23 Ocean Avenue plat

Fri, Sep 23, 2016 at 11:27 AM

Ocean Ave No 23 Site Subdivision Plat 9 14 2016 Survey Review 9 23 2016.PDF

SITE/SUBDIVISION PLAN (PRELIMINARY)
OF 23 OCEAN AVENUE
PORTLAND, MAINE
FOR RECORD OWNERS:
STEVEN E. AND ROBERTA S. COPE
P.O. BOX 1398
PORTLAND, MAINE 04104

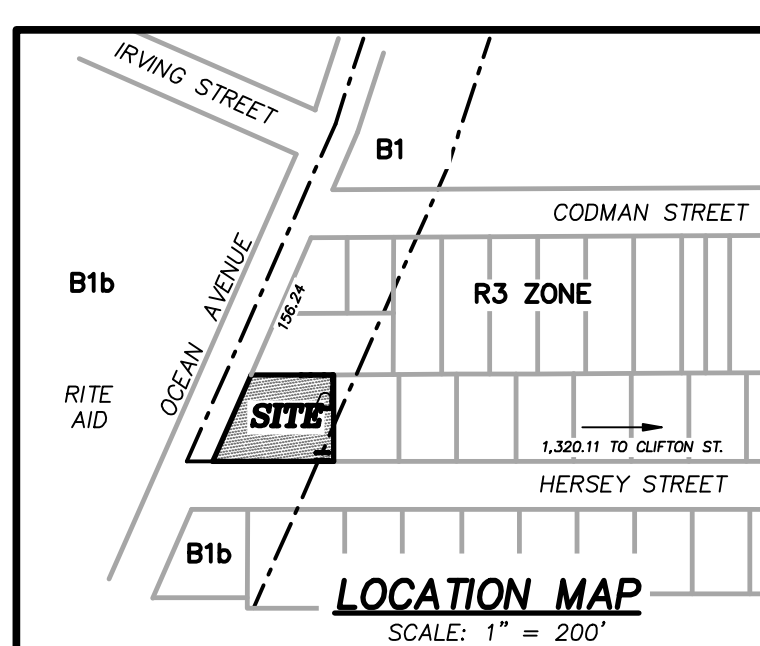
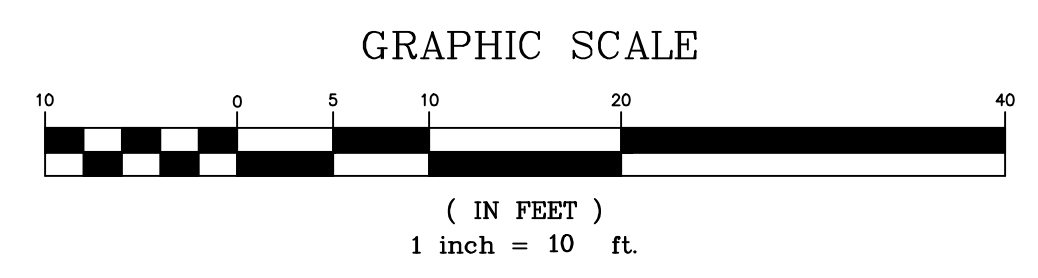
1. Add chord bearing and distance for the proposed pedestrian easement detail.
2. Add text "Proposed" before "Pedestrian Easement".
3. Possibly add height clearance for the one foot wide aerial easements along Ocean Ave and Hersey St.
